Recommendation Report for Planning Permission for Works or Extension to a Dwelling

REF NO: M/123/17/HH

LOCATION: Little Thatch
93 Middleton Road
Middleton on Sea
PO22 6DW

PROPOSAL: Two storey extension to existing building. Re-submission of M/71/17/HH

Nº 93 MIDDLETON ROAD
 DRG Nº : AB : 100 : 7
 Version 4
 For : MR A BARBARY
 Date : October 2017

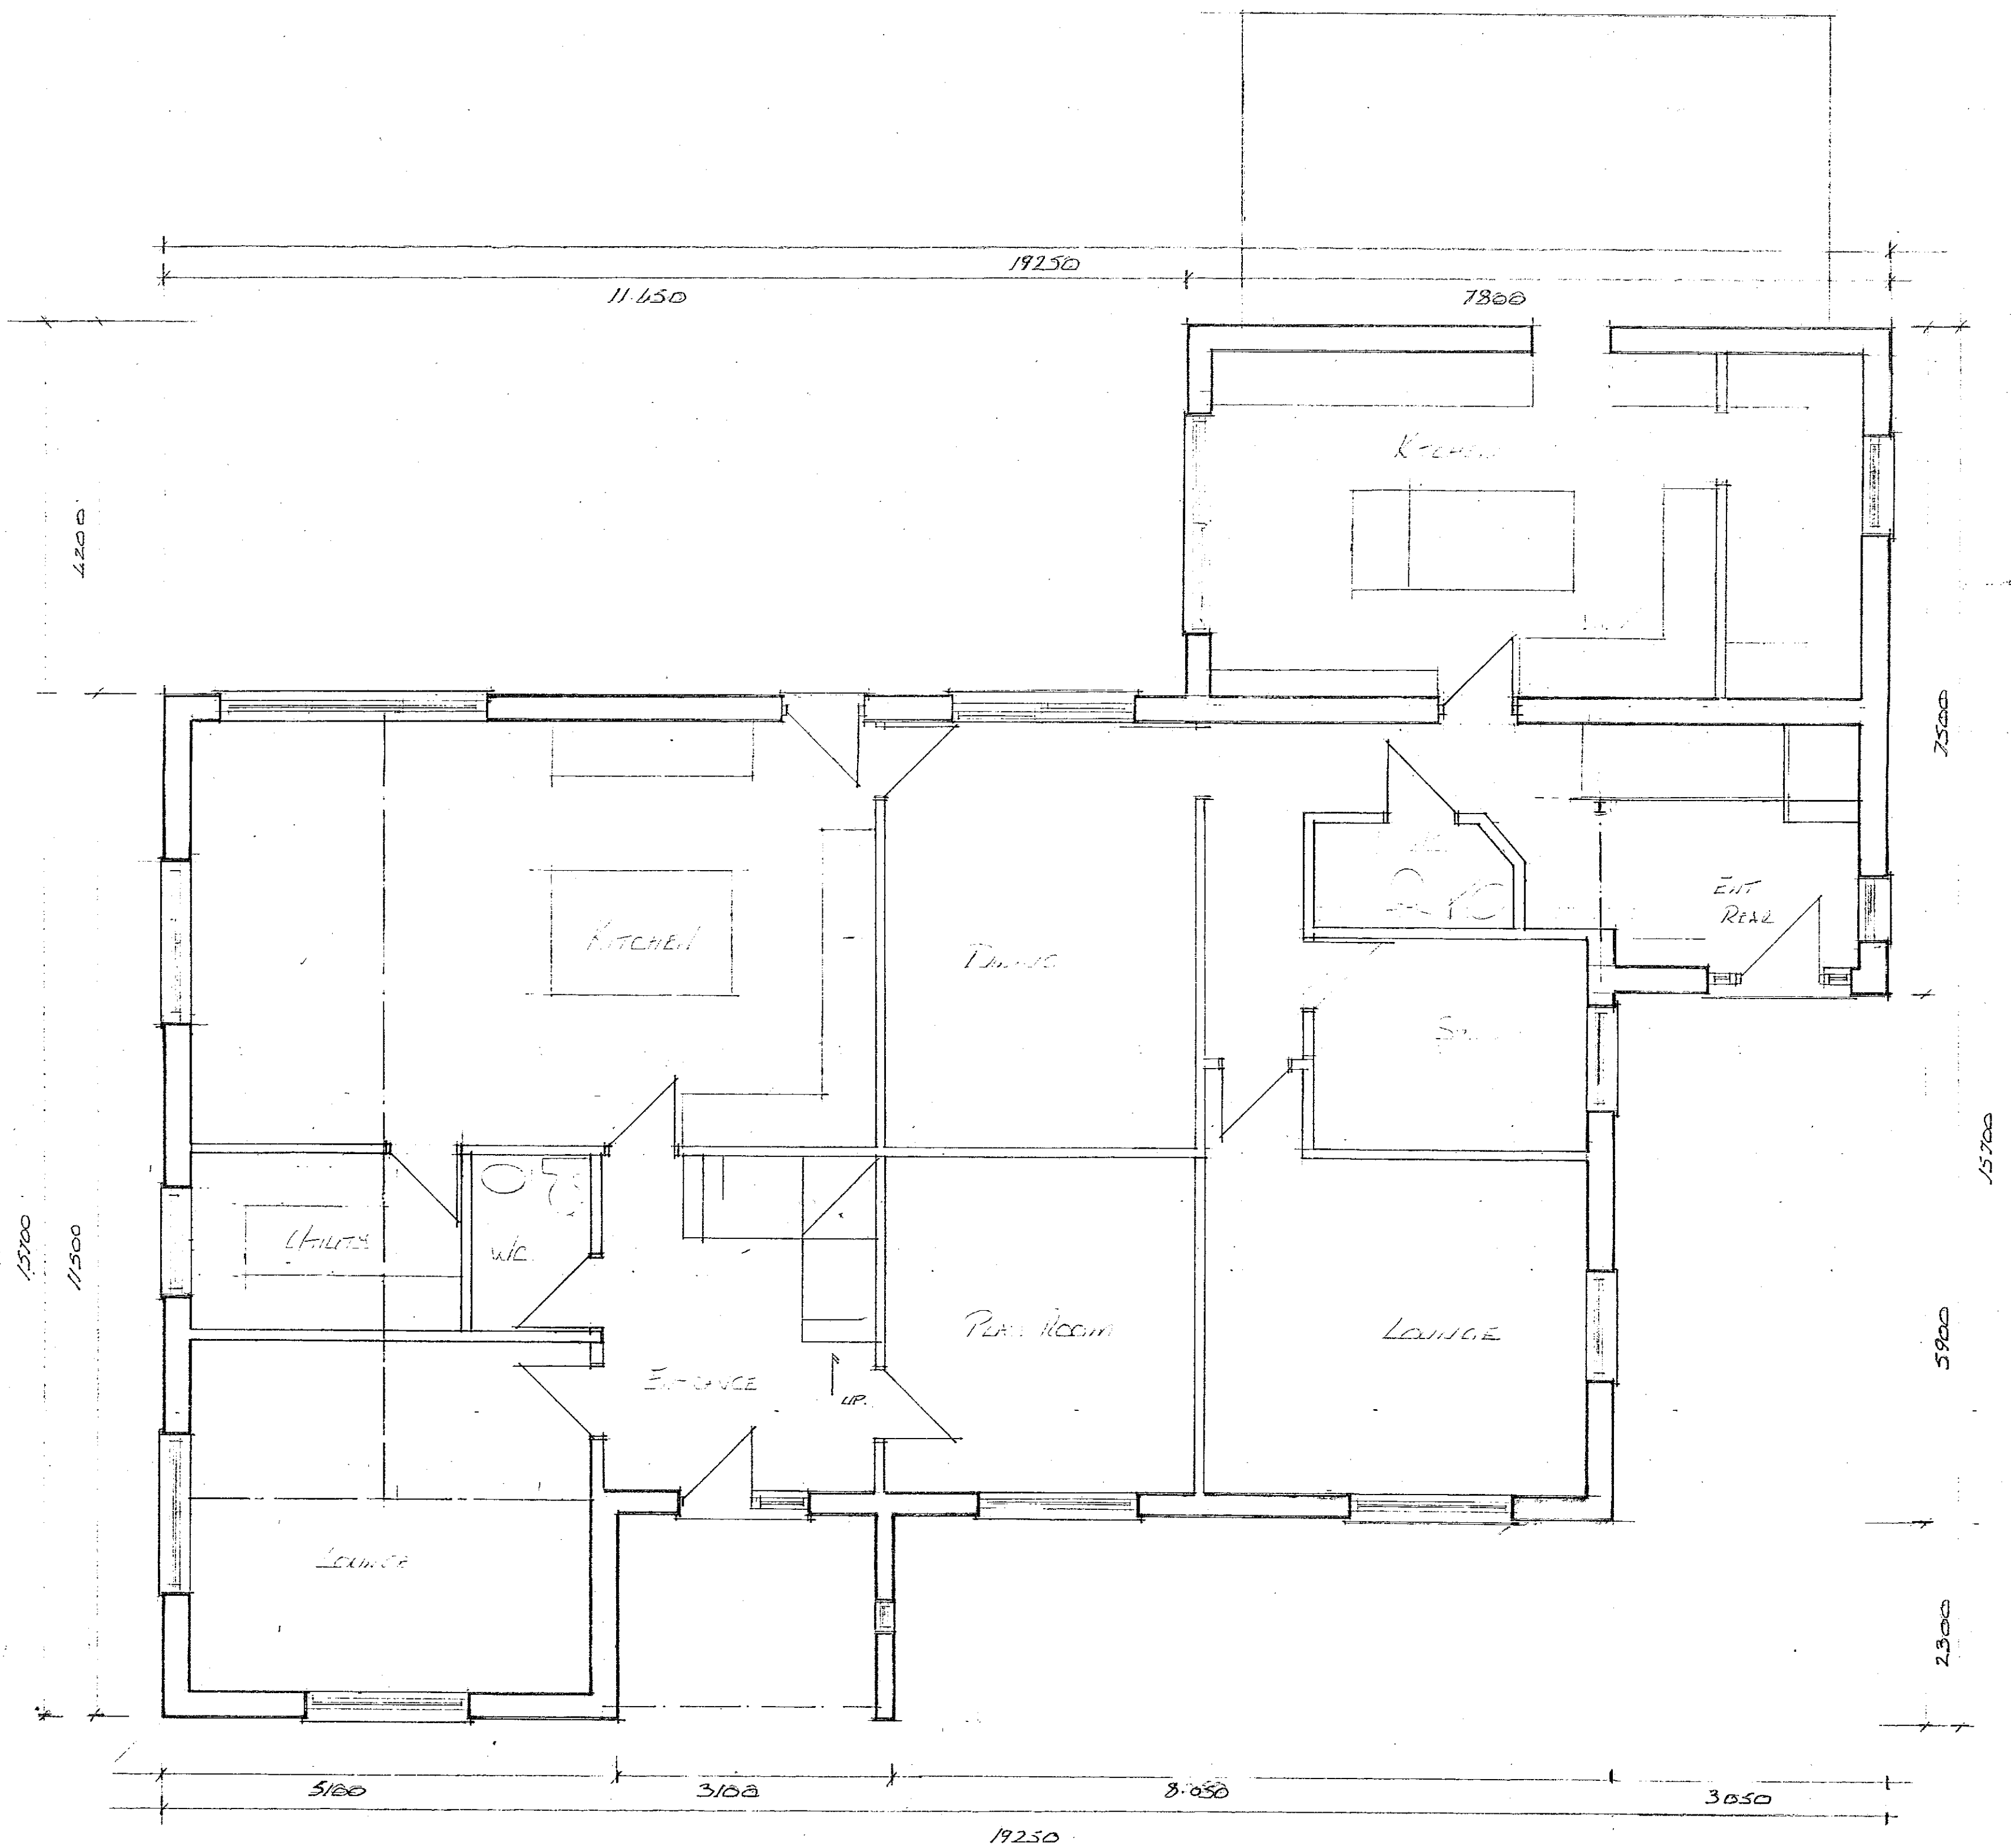
- Question the 1m gap annotated on the plan. The block plan also shows the boundary to house gap as 3.3m. Drawing number AB-100-7 V5 - 'proposed floor plan and elevation' shows this distance to be 3.4m. It is therefore requested that key boundary measurements are double-checked on site.

- A new set of scaled plans have been submitted to now clearly show the distance to the site boundary. The site, including the existing and neighbouring property, have been professionally surveyed which means that all distances shown are as accurate as can be.
- There is no requirement for the plans to include the updated footprint of the adjacent dwelling which has

DRG N° AB-100-4A,B,C

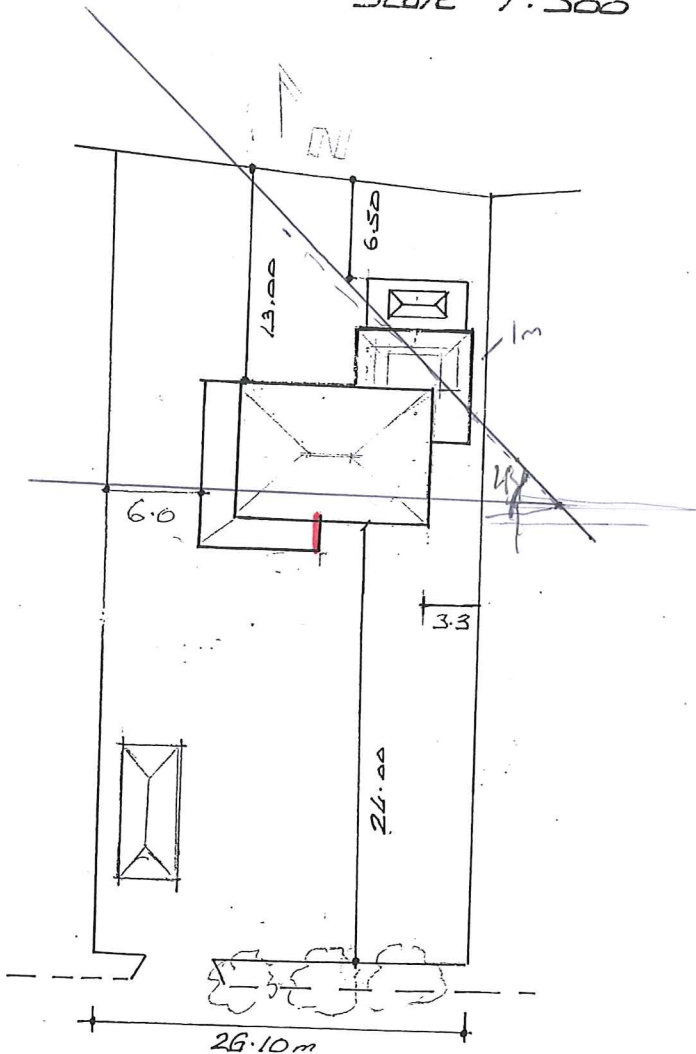
- Neighbouring property has not been included in the 1:500 Block Plan.
- The Location Plan is incorrect. Neighbouring house is not drawn to scale and is much closer to the boundary in reality.

been extended. However clearer plans have been requested and received which show accurate distances from the proposal to the neighbouring property.

DRC N°: AB: 100 12

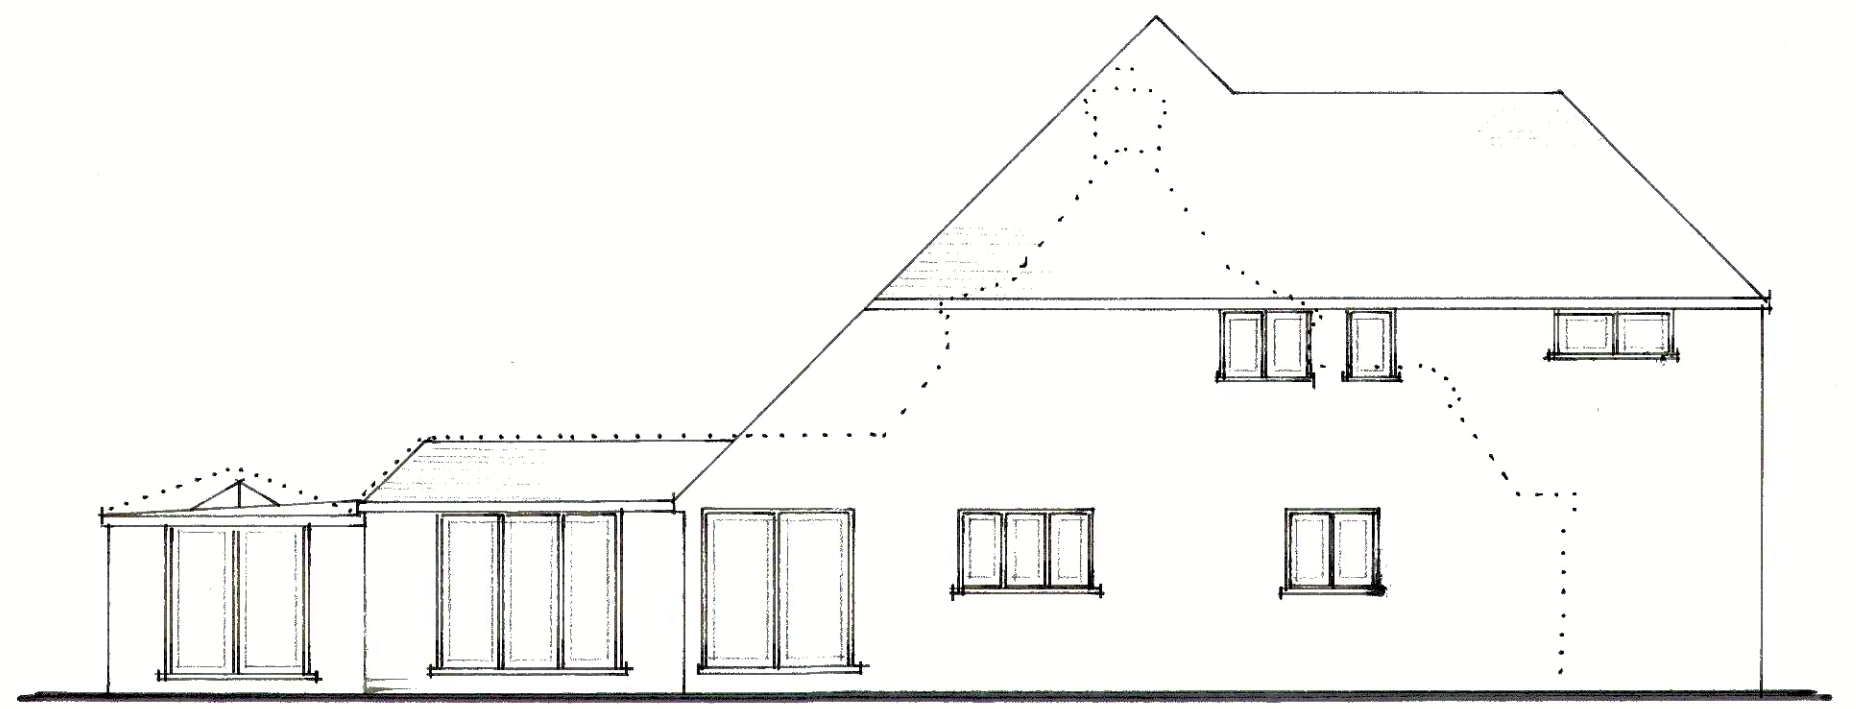
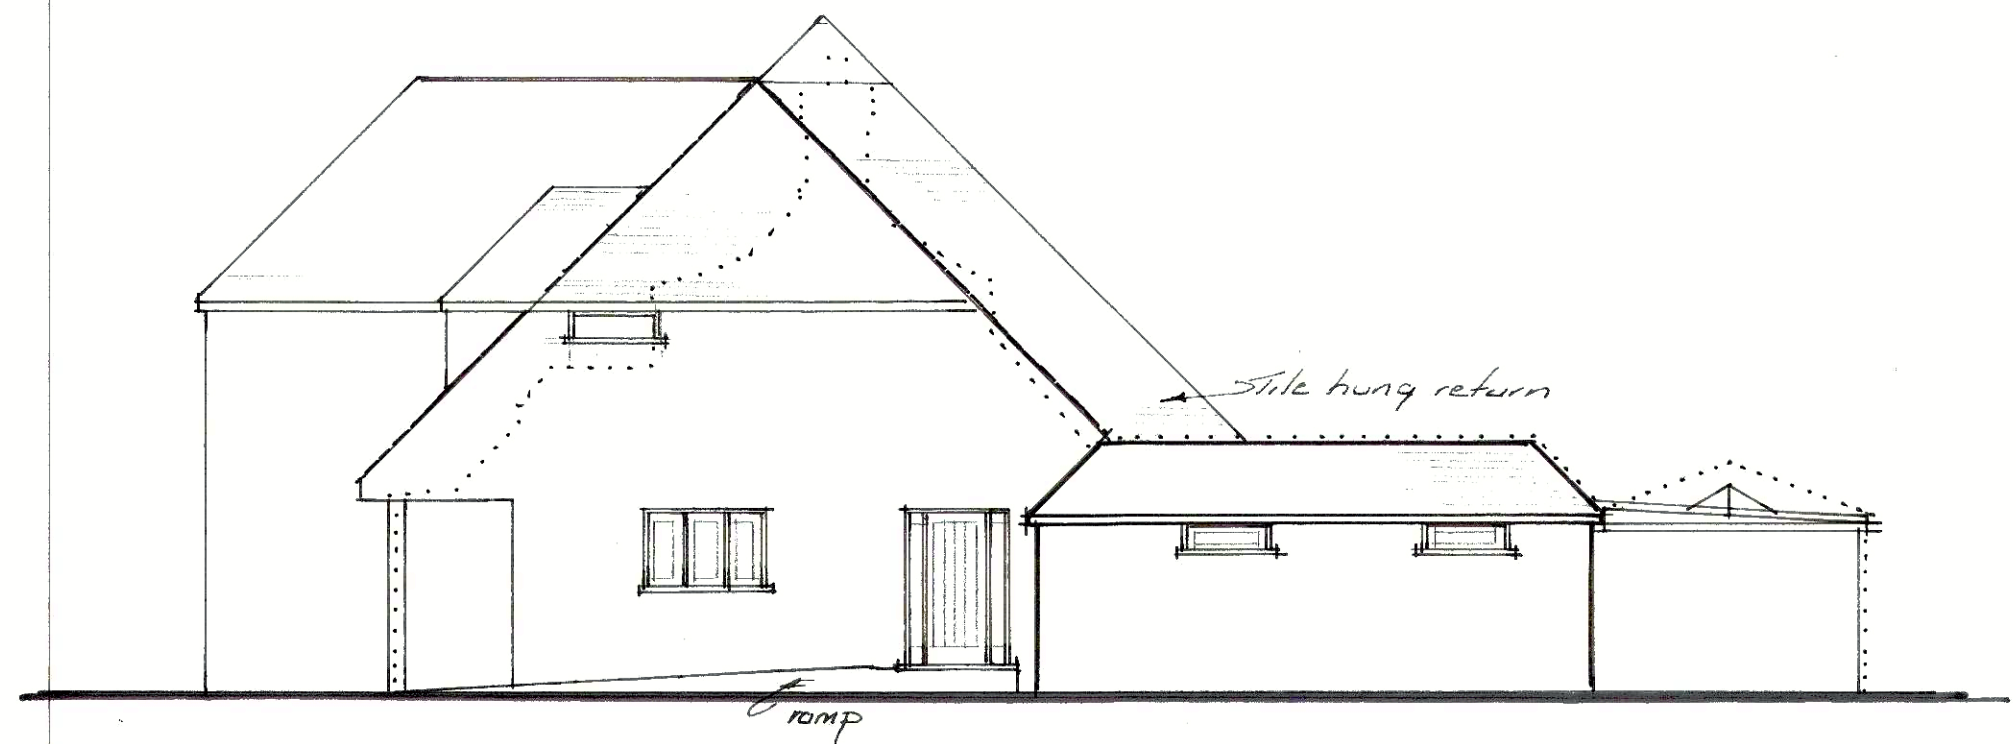
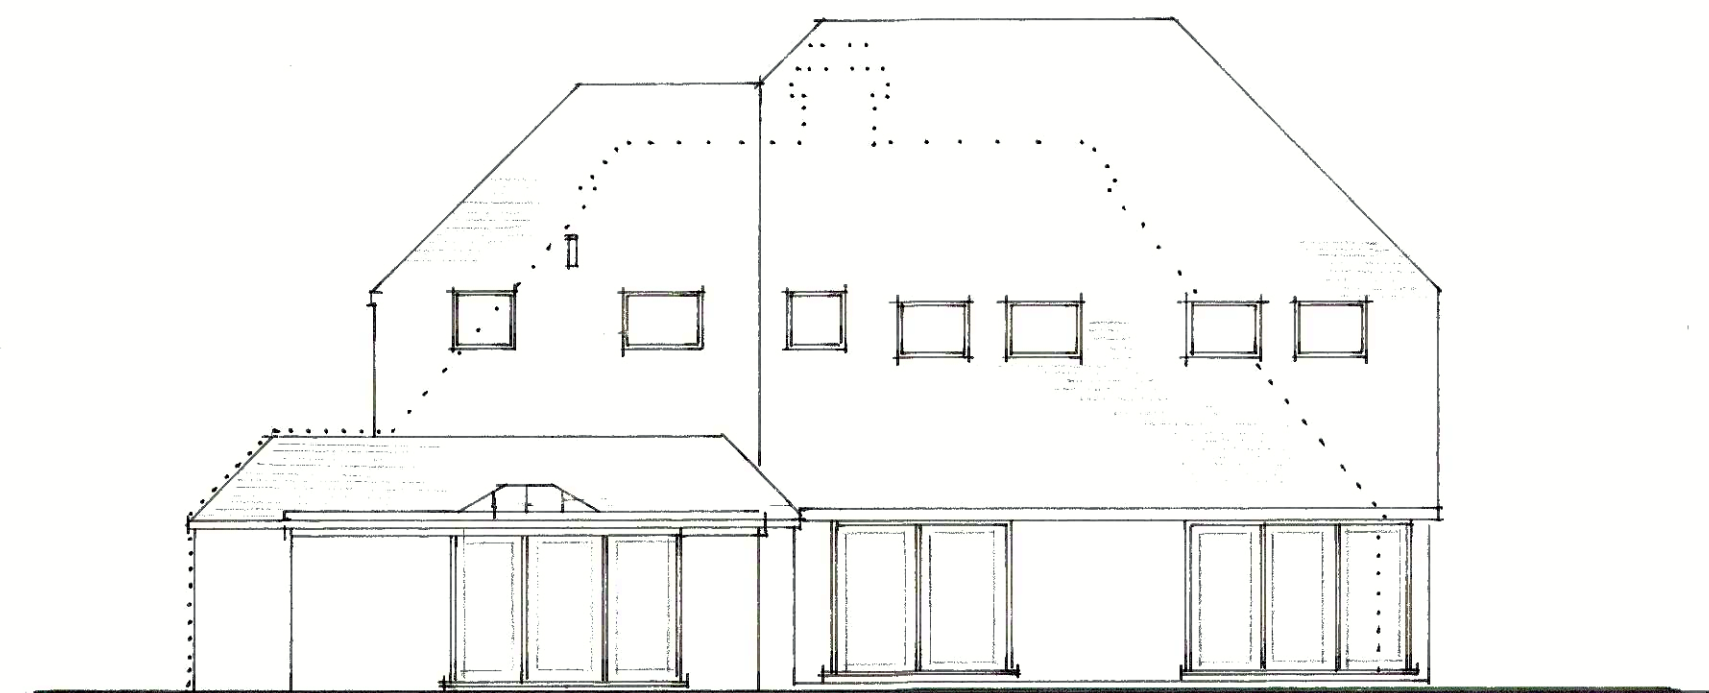
- It isn't clear how far the east elevation will be extended on its south side. The measurements are unclear. Currently there is a large flat roof glass extension to the lounge similar to a conservatory. If this is now to be incorporated in the southern roof line then the drawings are not to scale as this flat roof extends roughly 2m and is not shown on the dotted line on AB-100-12 V5.
